PLANNING AND INFRASTRUCTURE

14 July 2025

Re: State Significant Development Application Number SSD-73277714
Mixed-use development with in-fill affordable housing
37 Archer Street, Chatswood

Fig. 2. Extract of Section 02 from Details and Sections (Dwg. No. LA LP 112 / 01) from Appendix F Landscape Plans; RLs indicate a soil depth less than 530mm.

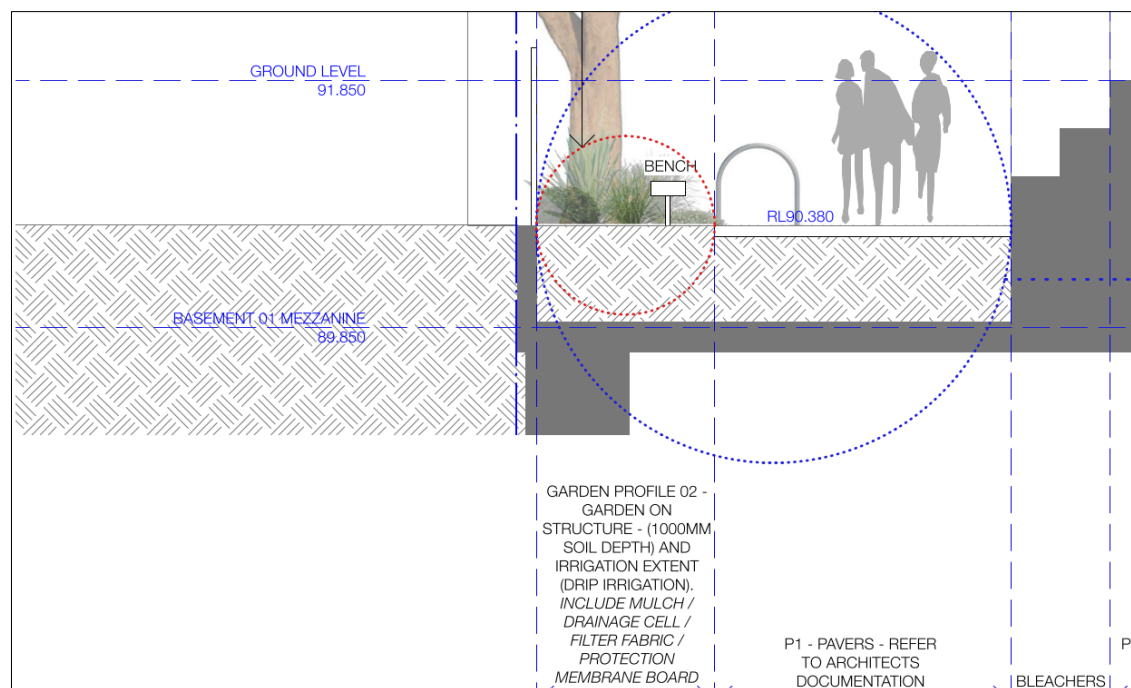
- The basement extends to the boundary on the north side. Section 02 on Drawing No. LA LP 112 / 01 within the Landscape Plans (Appendix F) annotate a soil depth of 1000mm to support the landscaping and proposed trees. However, the RLs show a total depth to the basement structure of less than 530mm. Willoughby DCP requires a minimum of 600mm soil depth to be included in landscape area calculations. For planting of large canopy trees (13-18m high with 16m spread) on structures the Apartment Design Guide (ADG) requires a minimum depth of 1200mm, with an area of 10m x 10m or equivalent with a soil volume of 150m³ per tree; the landscape plans show 5 trees which exceed 18m in height to be planted on structure.

- A minimum soil depth of 1200mm could be capable of supporting the proposed canopy tree species.
- In addition to the minimum soil depth requirements, sufficient soil volume must also be provided to support the trees.
